Listed building consent for the replacement of 2 No. windows & 1 No. door with PVCu Heritage Flush type to rear elevation & removal of walls in upper second floor for open kitchen plan & replace boxing with enclosure in lower hallway & reinstatement of handrail to match existing.

Second Floor Flat 37C South Terrace Littlehampton

Thank you for your internet comments made on 29th April 2020 which has been recorded as **'an objection'** with the comments as follows:

Proposed East Elevation of Rear Outrigger - 1/100

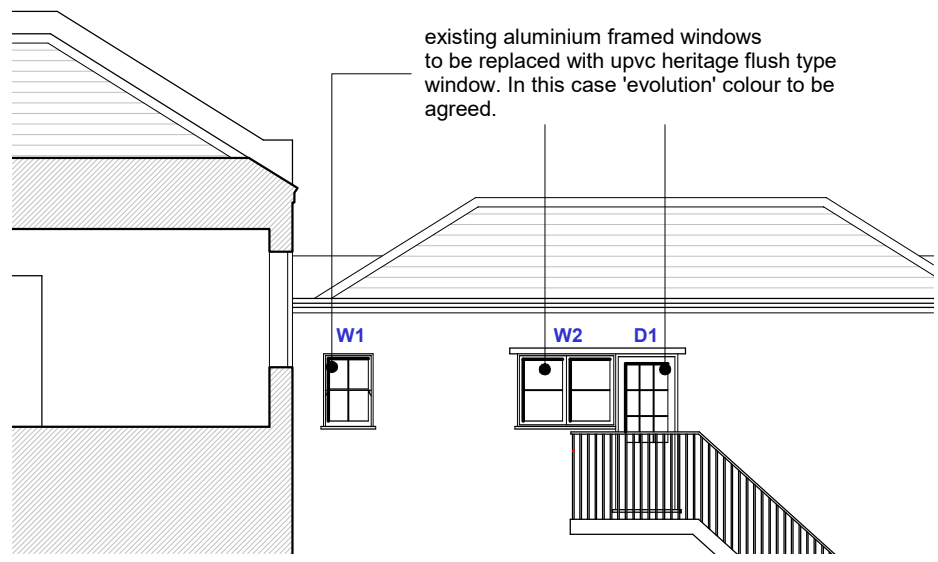
Littlehampton Town Council object on the grounds that the design and materials proposed are out character, contrary to Arun Local Plan Policy D DM1 Section 1. The site is also located within the Littlehampton Seafront Conservation Area and protected by Policy HER SP1 which states "Conservation Areas will be given the highest level of protection and should be conserved and enhanced in a manner appropriate to their significance. Development likely to prejudice any of the above, including their setting, will be refused". Policy HER DM3 also states that planning permission will only be granted within a conservation area where the use of materials acknowledges the importance of the area. The proposed use of PVCu has the potential to "erode the appearance" of these areas and should therefore be resisted.
